**KIRKLEES METROPOLITAN COUNCIL
INVESTMENT & REGENERATION SERVICE**

DELEGATED DECISION TO DETERMINE PLANNING APPLICATIONS

Reference No:	2024/62/90389/W
Site Address:	25, Ivy Street, Crosland Moor, Huddersfield, HD4 5RB
Description:	Erection of staircase to front elevation with replacement porch roof and alterations (retrospective)
Recommending Officer:	Laura Yeadon

DECISION - REFUSE

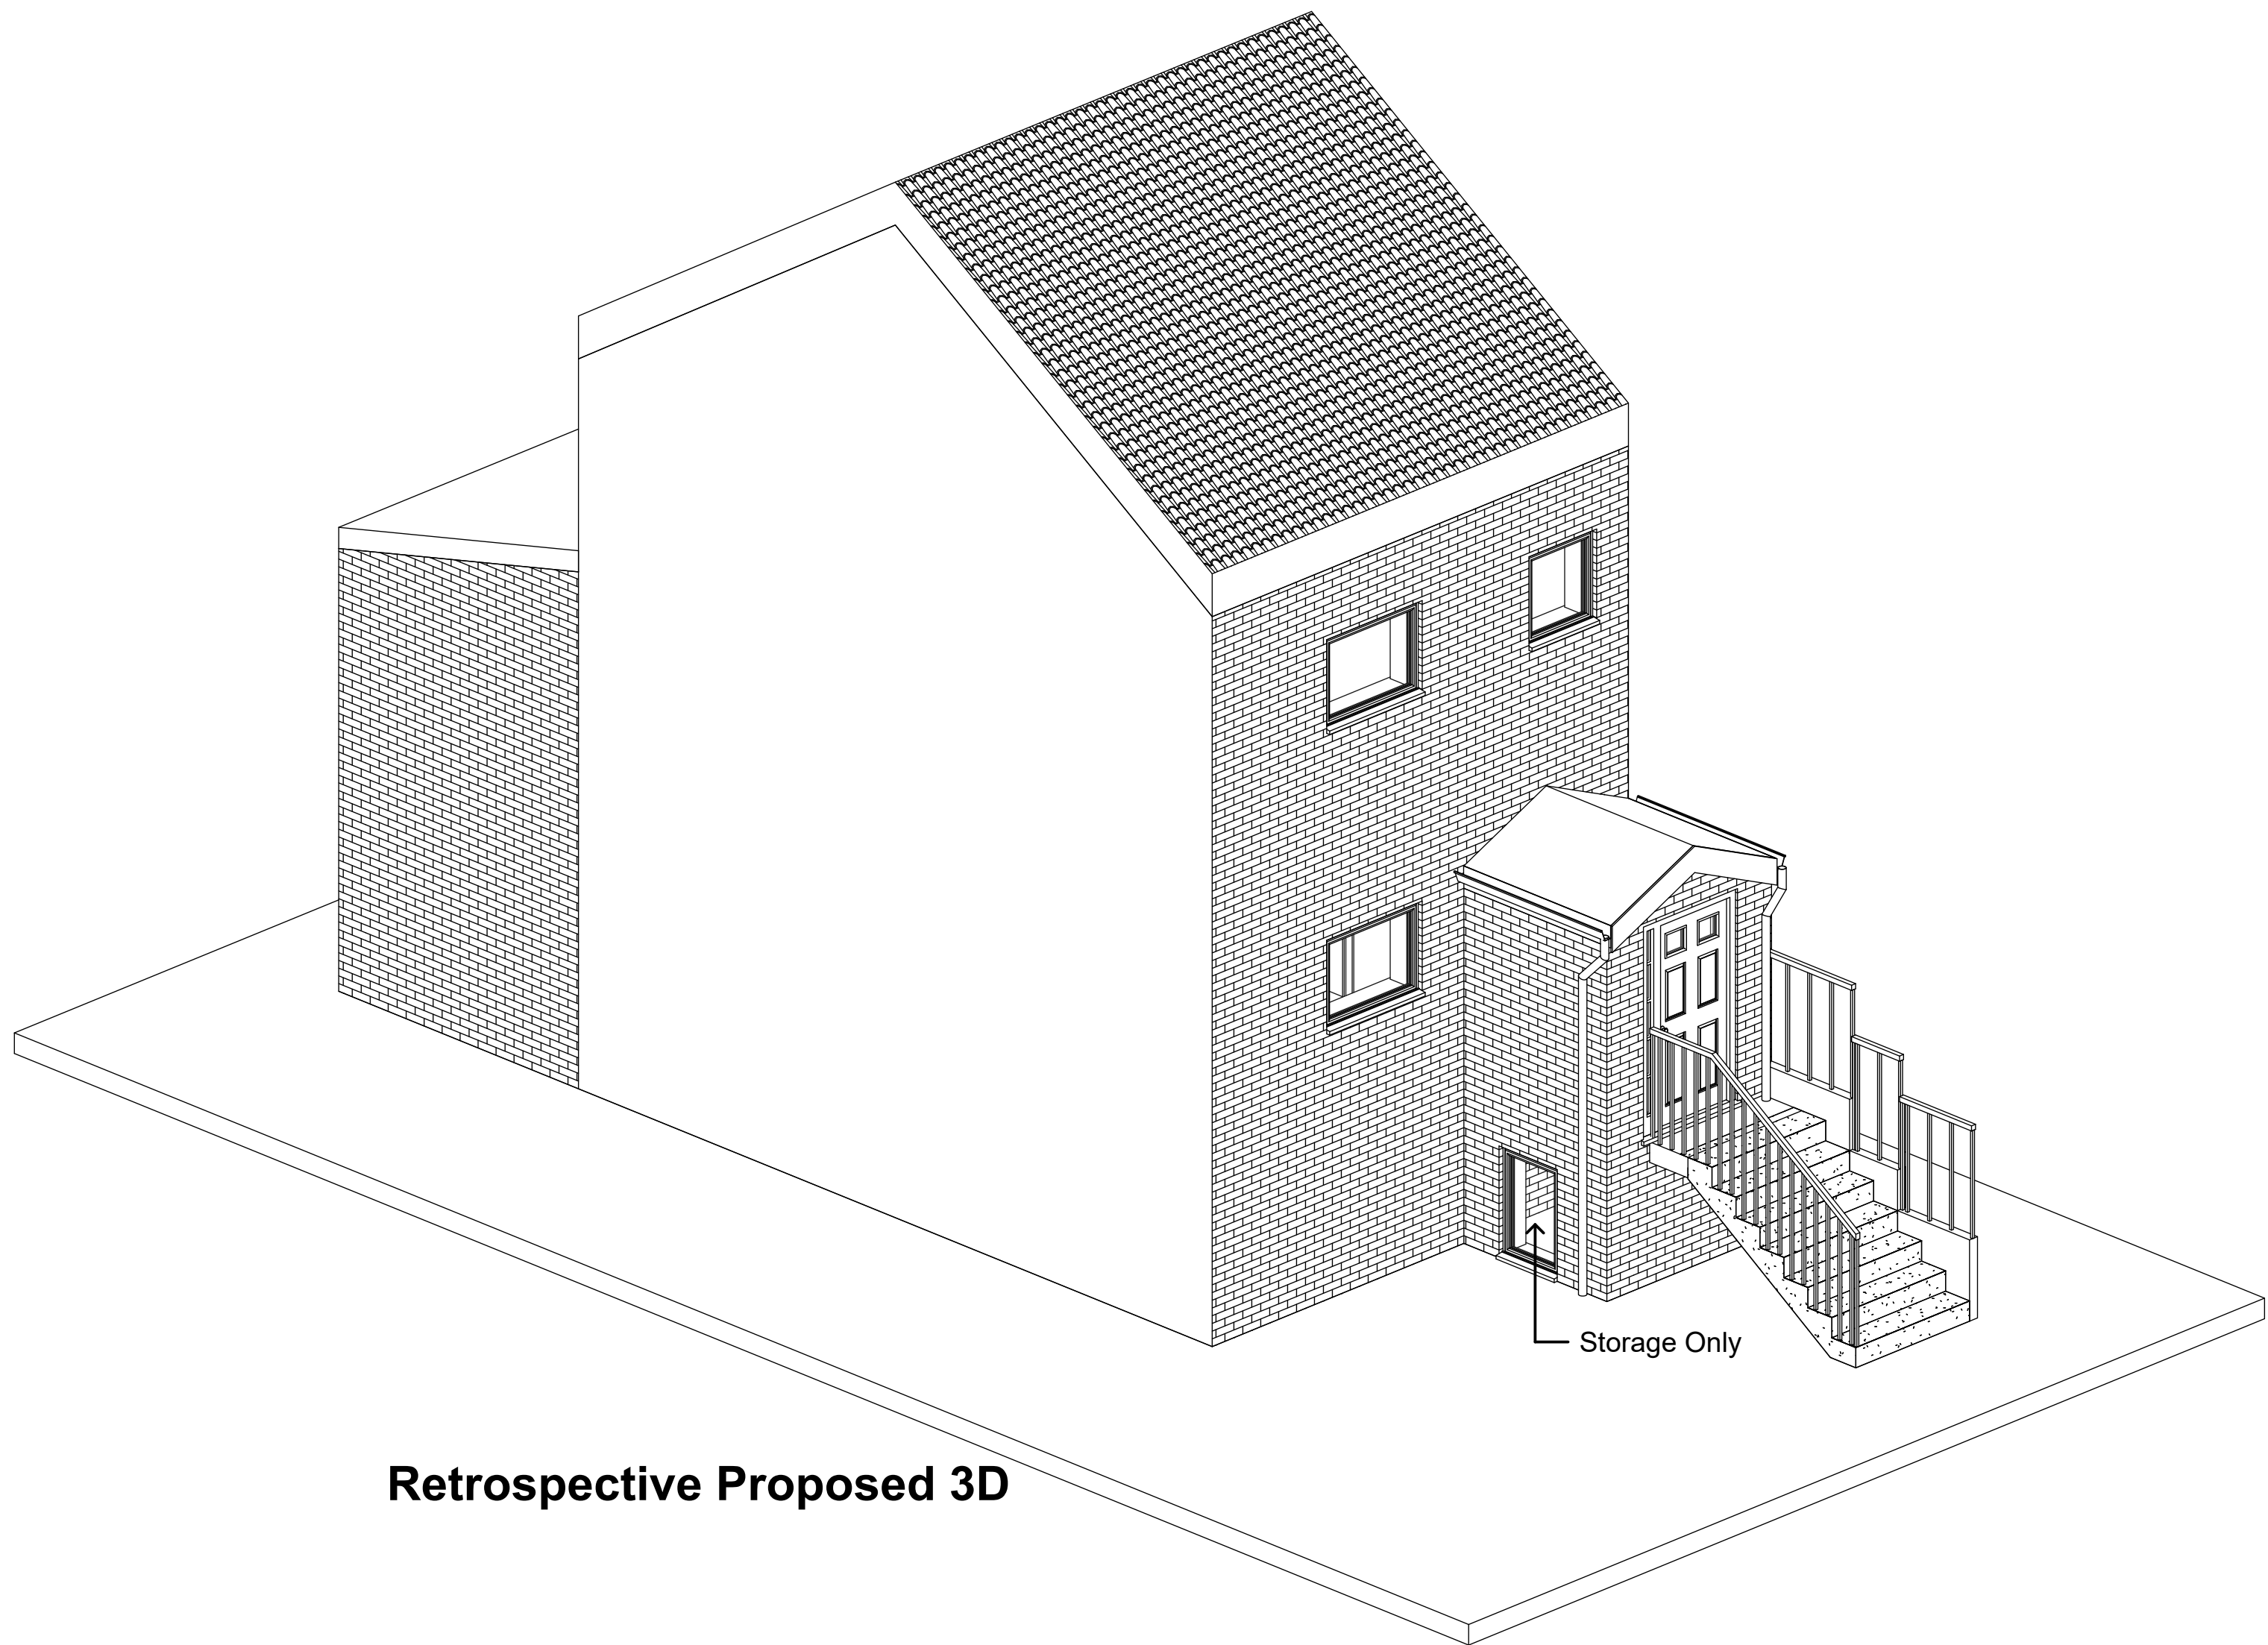
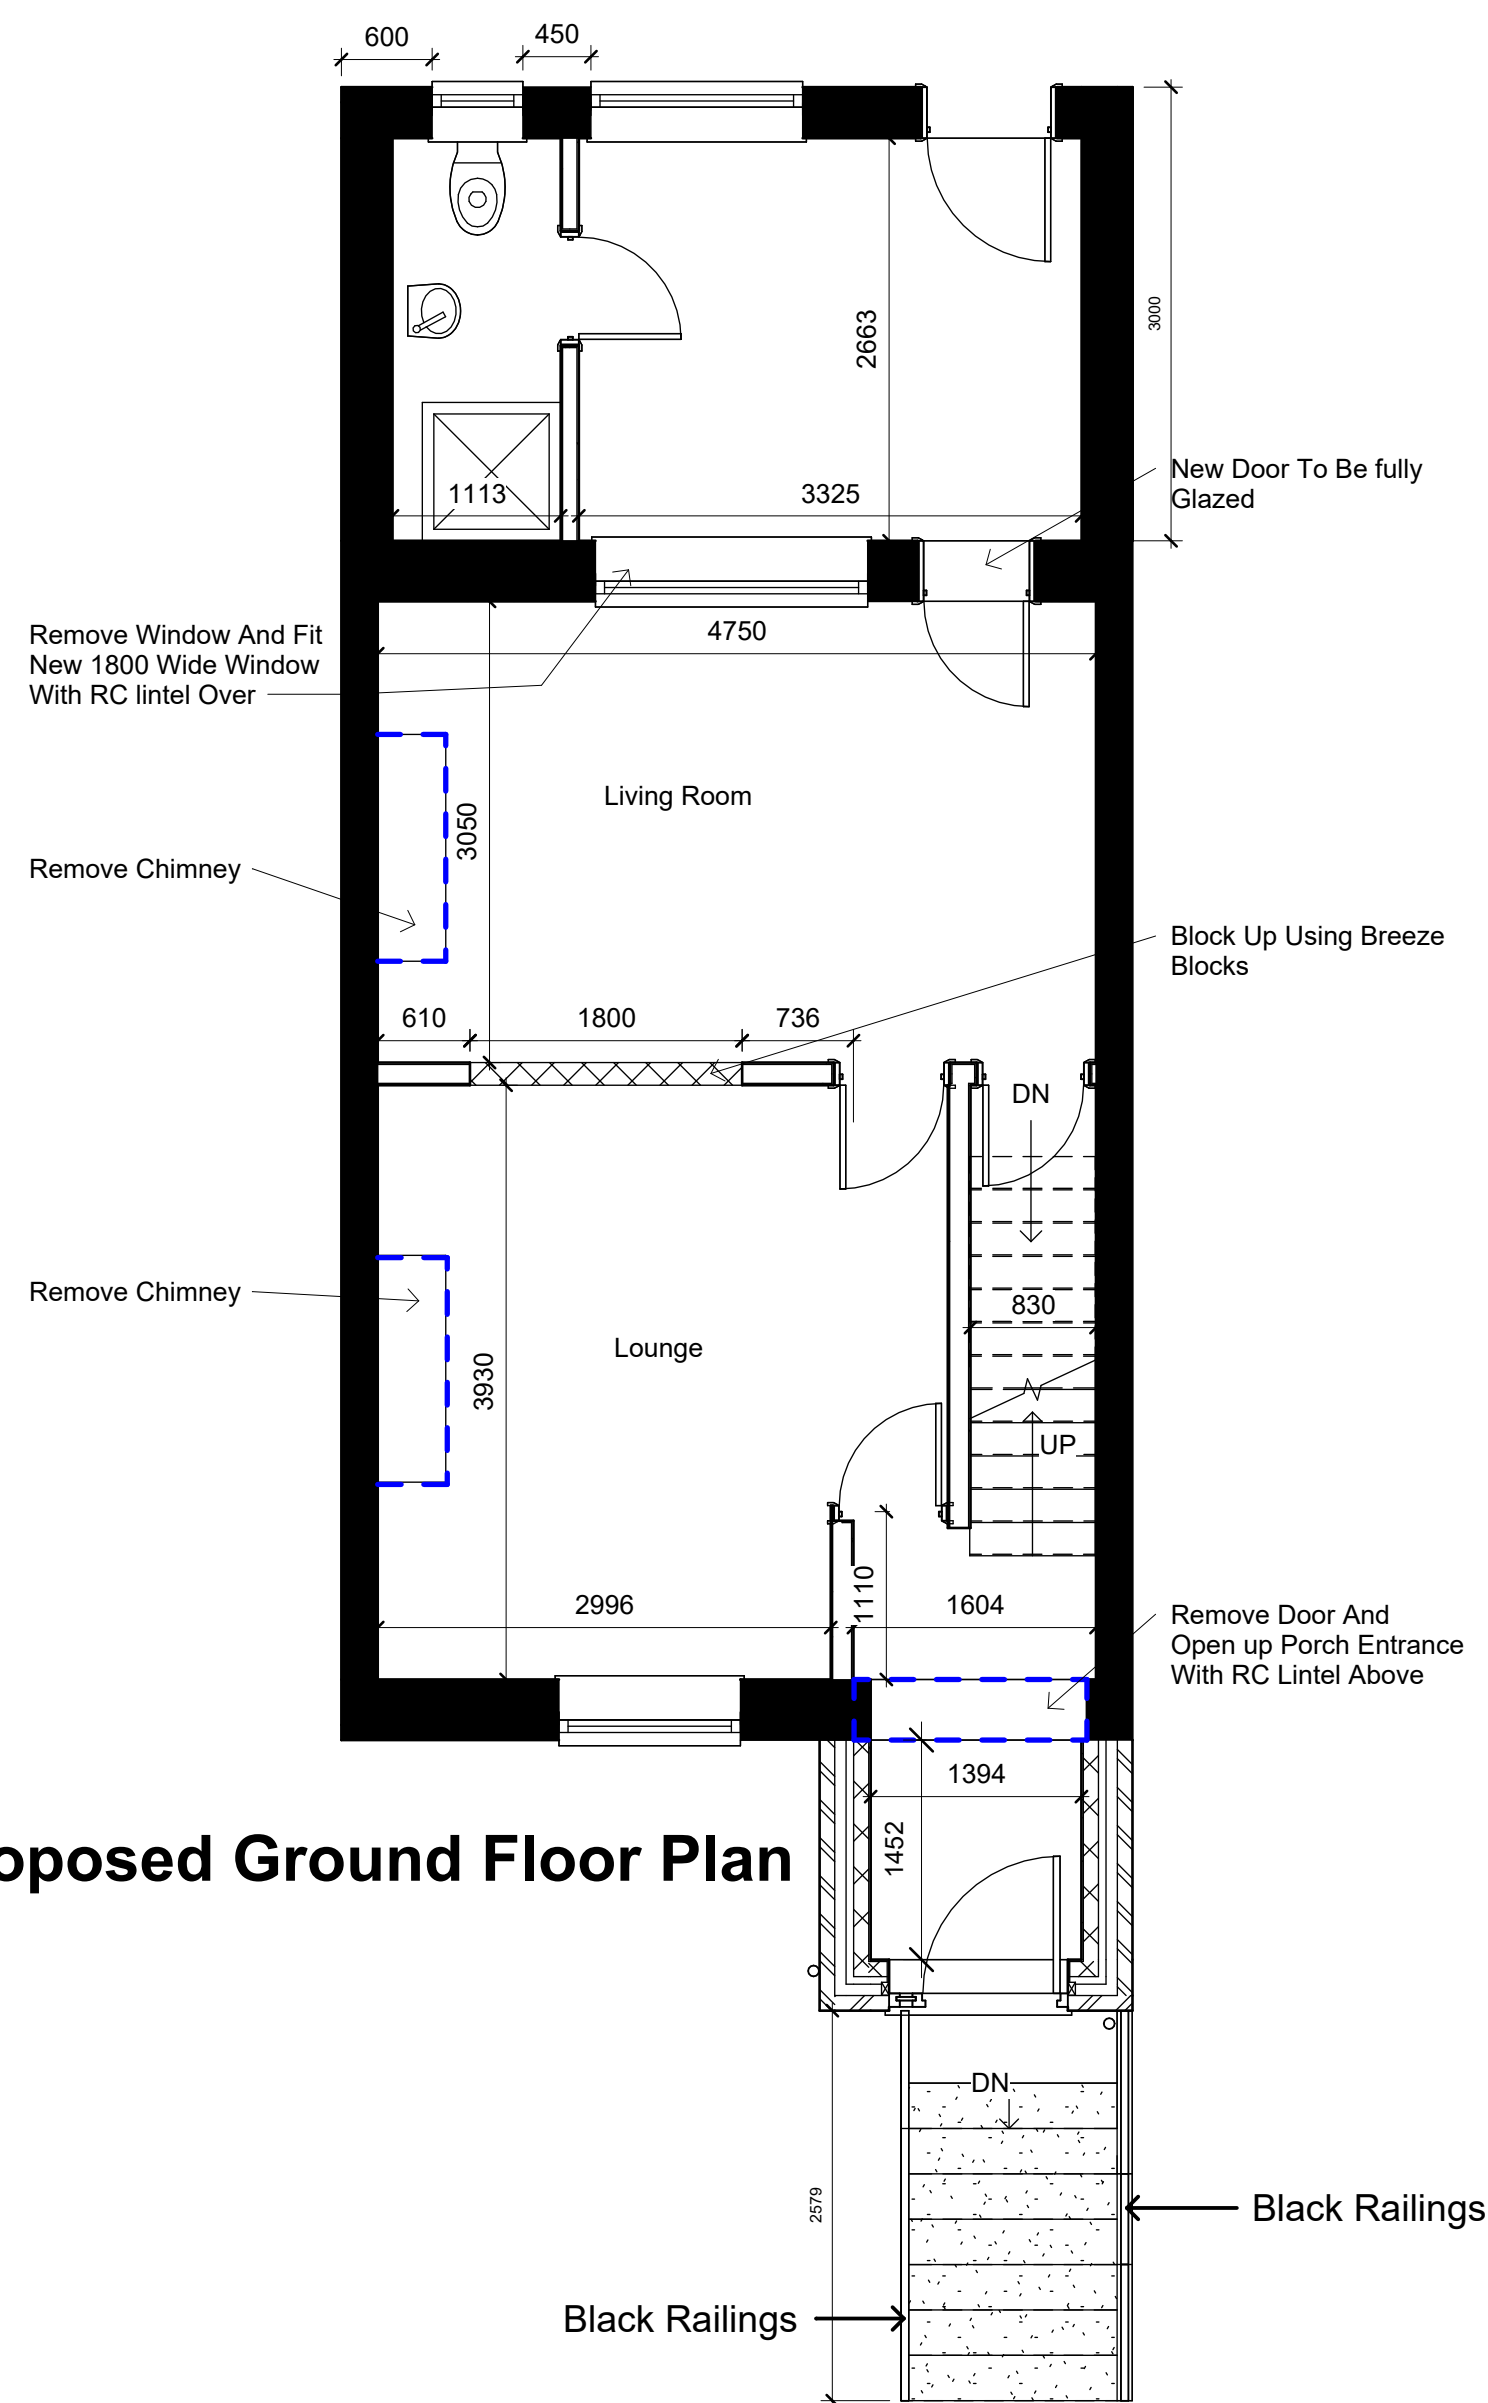
No negotiations have taken place with the applicant/agent due to the application being submitted retrospectively. Clarification was sought from the Agent as it was noted on site that there was a side elevation opening within the staircase. The Agent confirmed that the window was only to allow light into the storage area. Updated plans demonstrating the opening were subsequently received.

The creation of the staircase extends forward of the front elevation of the porch by an additional 2.6 metres which results in a prominent structure within the street scene. There is a uniformity of flush front elevations within the terraced row which does not host any other front porches. Due to the prominence and depth of the staircase, in conjunction the pitched roof which has more visual
